Property: 6-16 Atchison Street, St Leonards

**Proposal: Section 75W Modification to allow an additional 4 levels to an approved
Mixed Use Development**

MODIFICATION REQUEST – SECTION 75W MODIFICATION TO MIXED USE DEVELOPMENT AT 6-16 ATCHISON ST, ST LEONARDS (MO-09_0187 MOD 3)

EAST ELEVATION

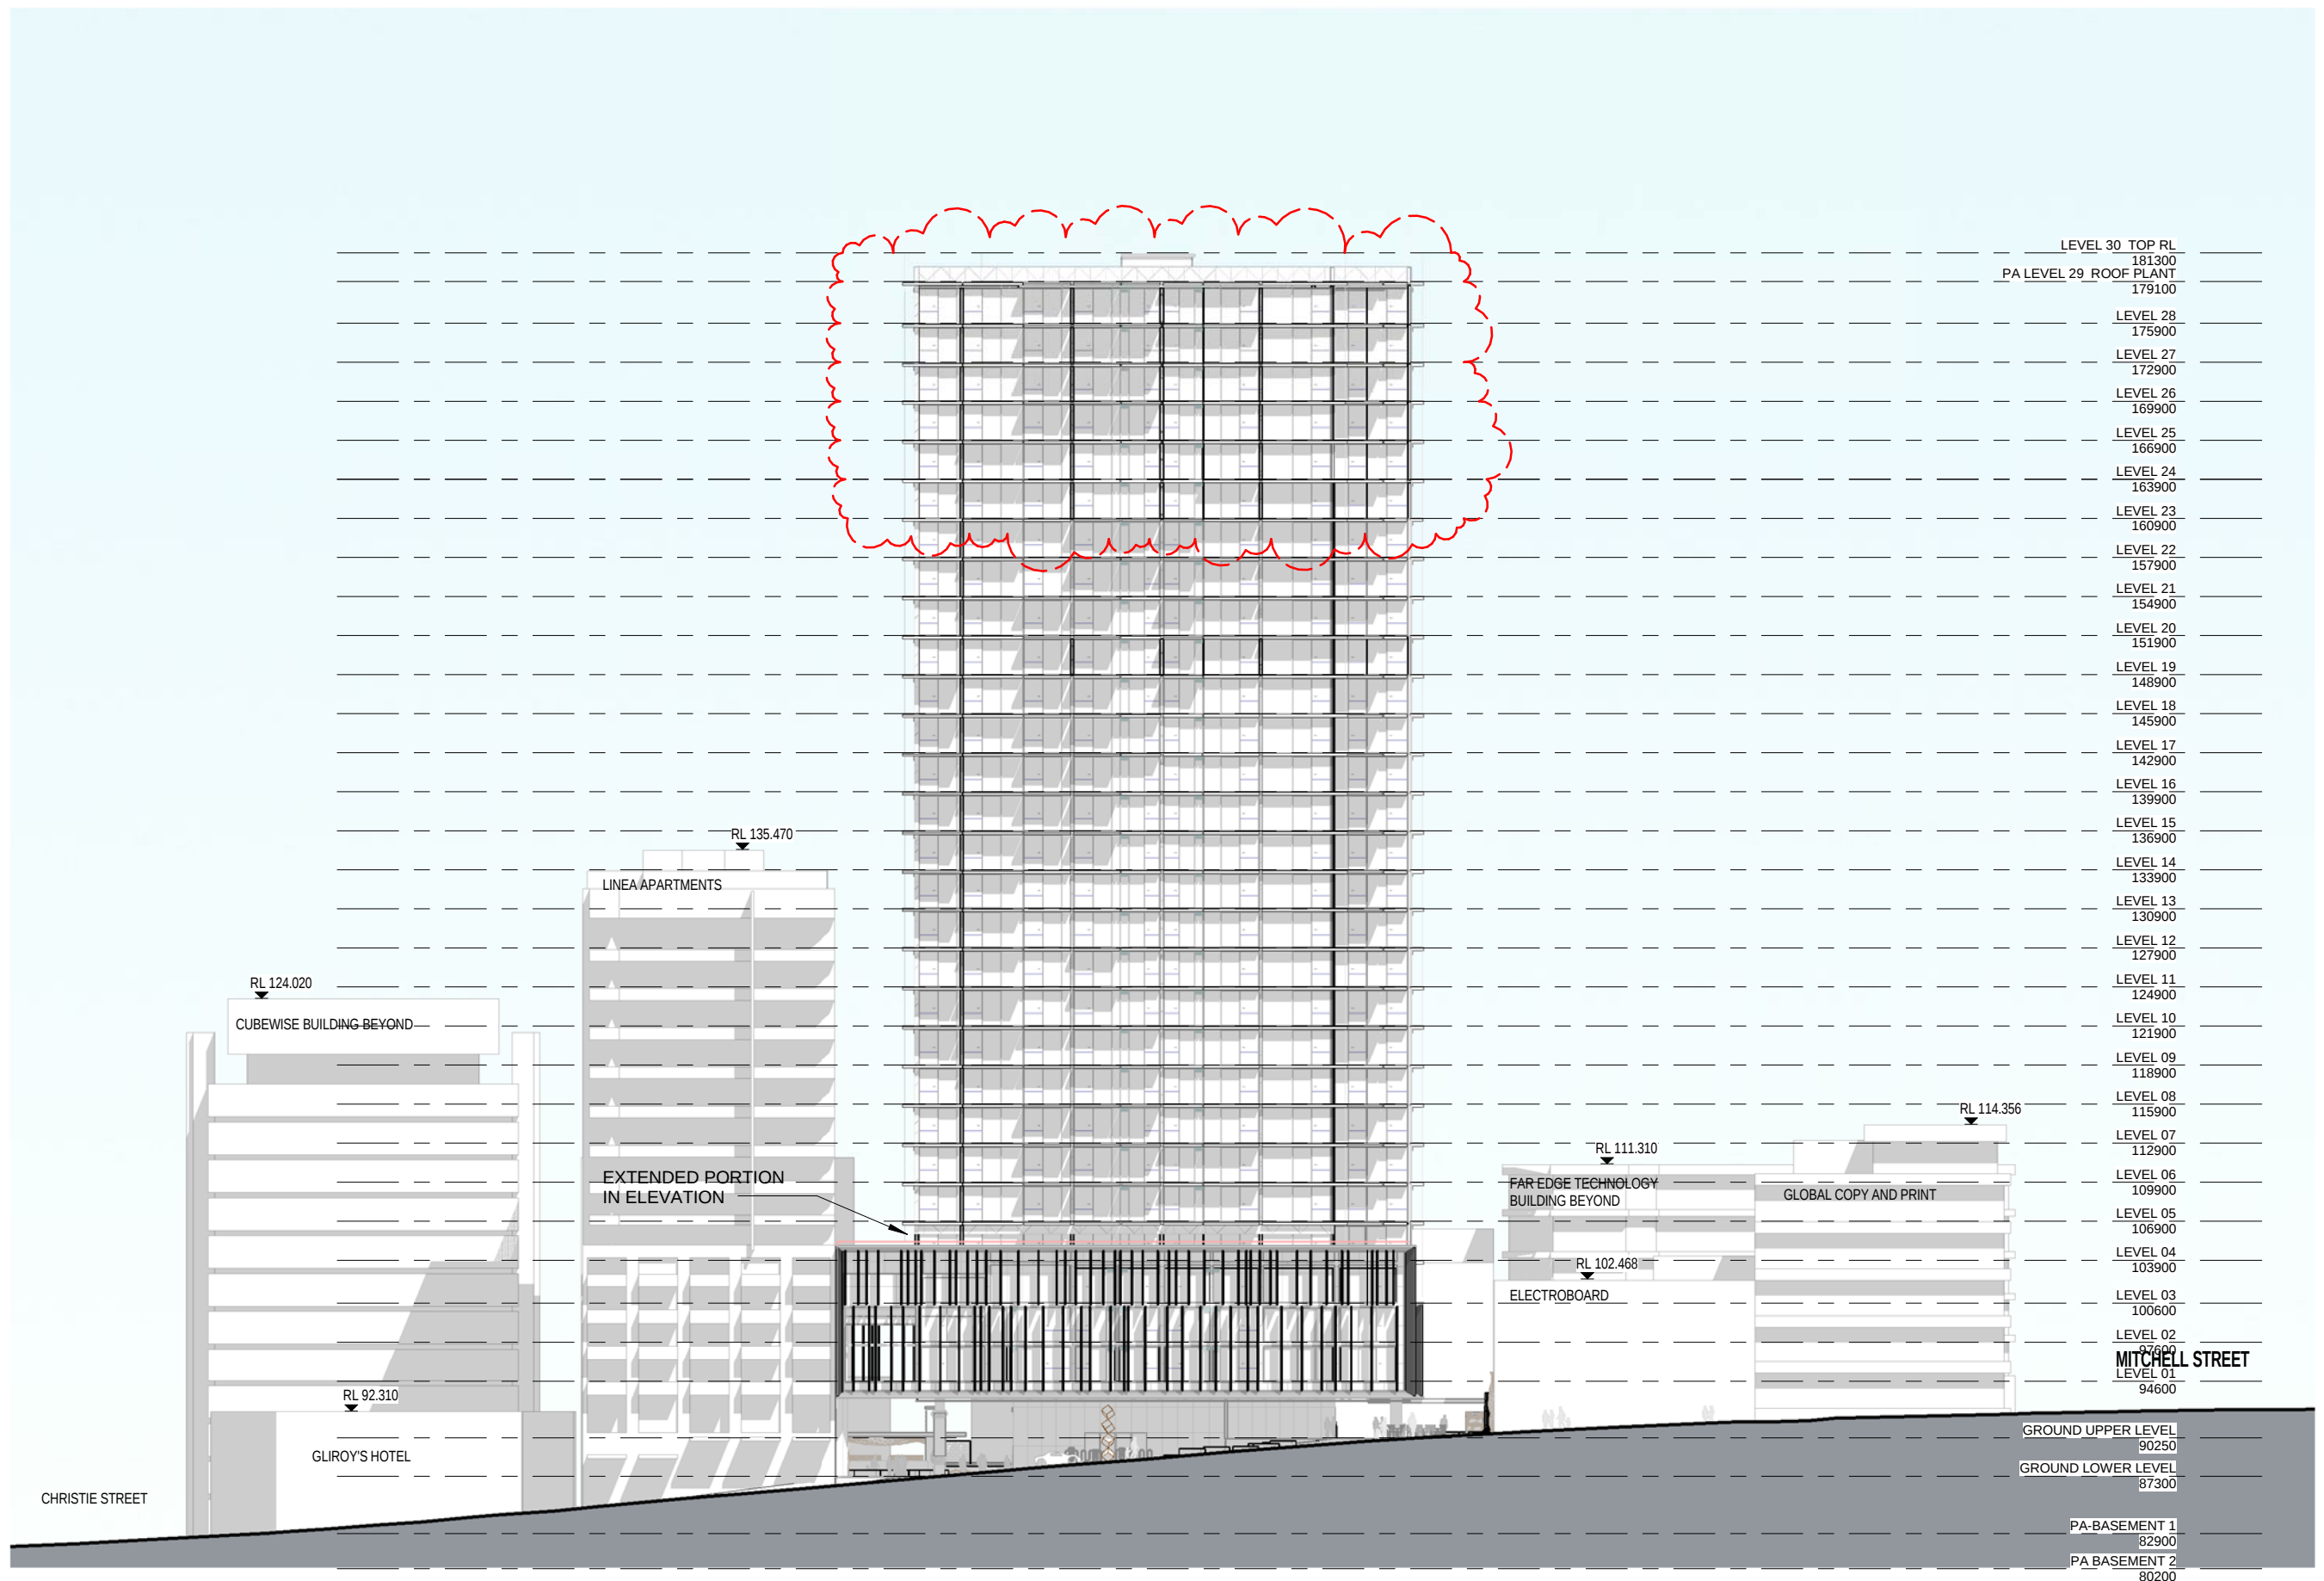
It is recommended that the applicant liaise with the adjoining property owner at No.20 Atchison Street to ensure that levels between the two proposed through site links from Atchison Street to Atchison Lane relate as far as possible. Structures on the eastern boundary should be minimised as far as possible.

B. VIEW DOWN ATCHISON STREET FROM THE NORTH WEST - 181.3m

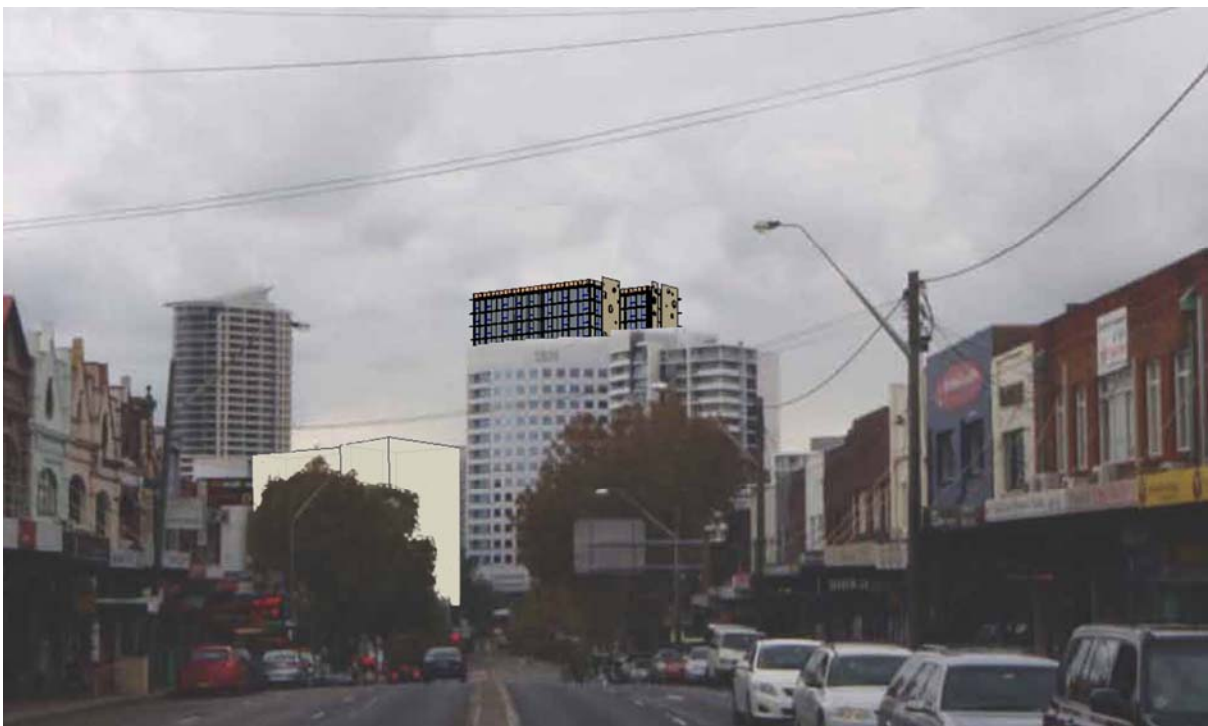
The proposed additional building height to be increased from RL167.3m (82.5m) to RL 181.3m (94m) AHD is strongly opposed. The North Sydney LEP 2013 sets a maximum Building Height of 49m on the site. Council strongly opposed the approved building height and form at the time. The proposed modification is seeking to reinstate an additional 4 levels that were previously refused by the Planning and Assessment Commission as part of the original development consent. This additional height continues to be without merit and should not be supported. The approval as it stands is considered to have compromised the orderly development of land in St Leonards.
